Your ref: 3/2017/0742

Date: 13th October 2017

Planning Applications 3/2017/0742: Demolish existing farmhouse and rebuild. Change of use of agricultural barn to two dwellings. Change of use of mono-pitch farm building to a garage for the barn conversion. Demolish four farm buildings. Dismantle and rebuild one timber-framed agricultural building in new location on the site. Reorientation of one steel-framed agricultural building. Startifants Farm, Longridge Road, Chipping PR3 2QB

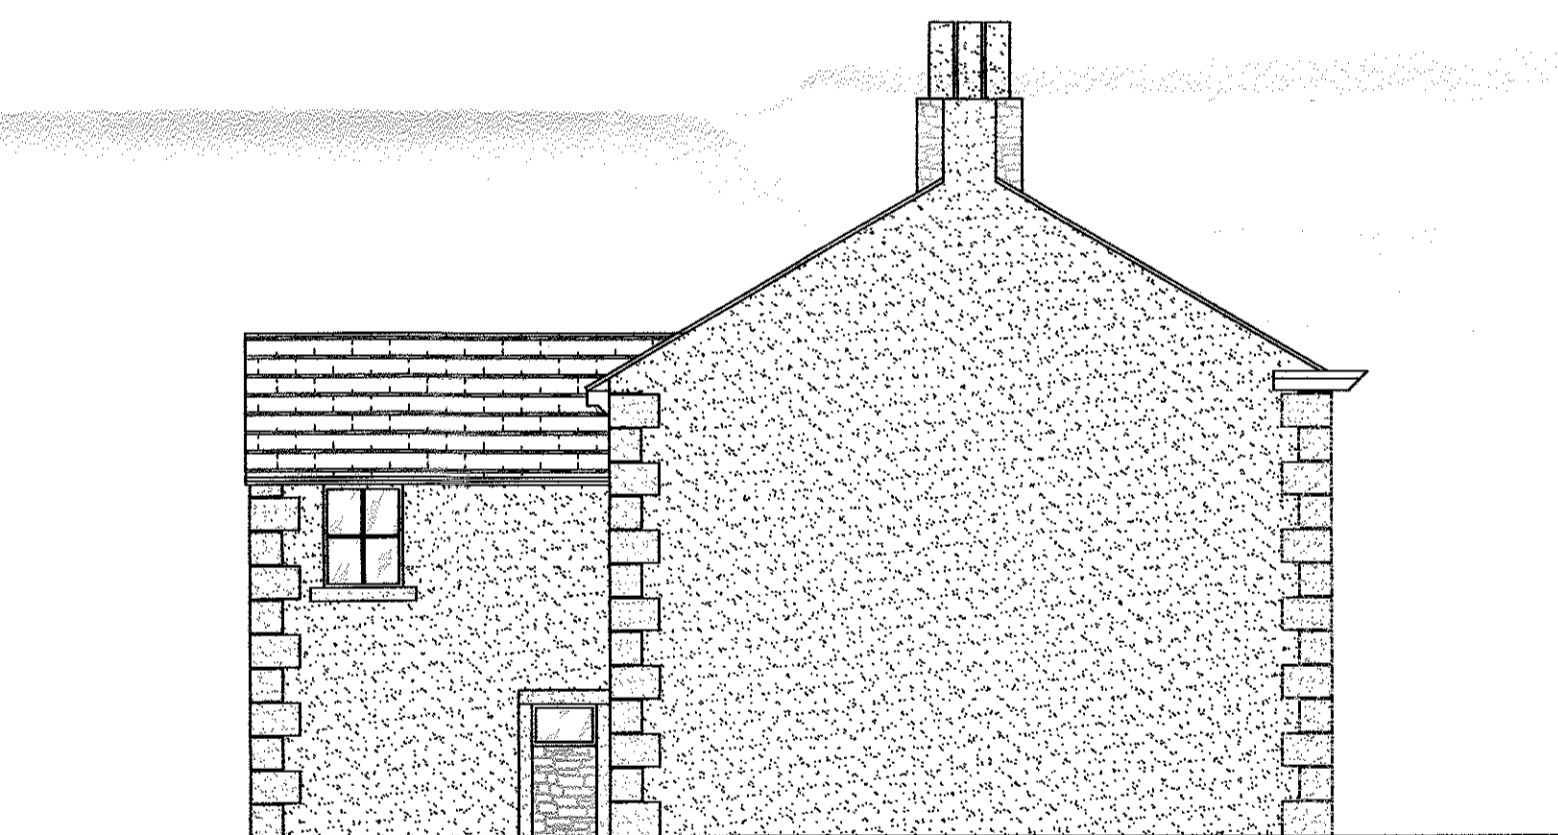
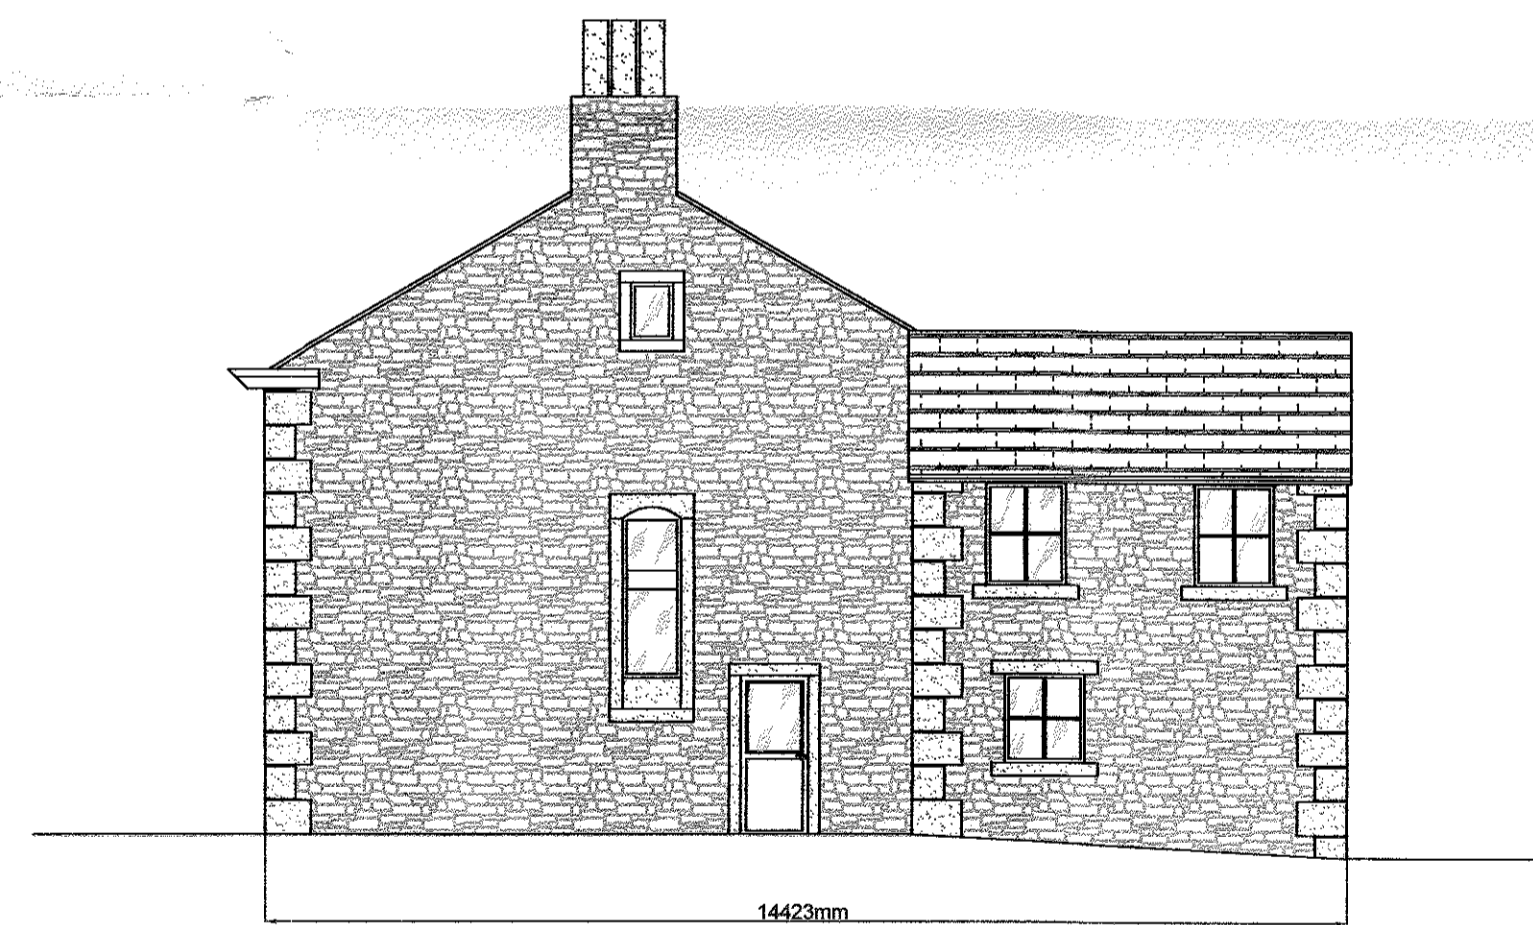
This application seeks to make considerable changes to this farmstead, but of the elements proposed those with heritage impacts appear to be (i) the demolition of (and replacement of) the extant farmhouse; and (ii) the change of use of a traditionally-built barn to two dwellings.

Given this history, it would seem appropriate to require that a formal heritage statement be produced and submitted as part of the application, prior to its determination. This should assess the significance of the farmhouse and barn and the impact of the proposals upon this as described in NPPF section 128. Without such an assessment it is not possible for an informed decision to be made concerning the balance of harm or loss of significance with regard to the benefits of the development (NPPF 135).
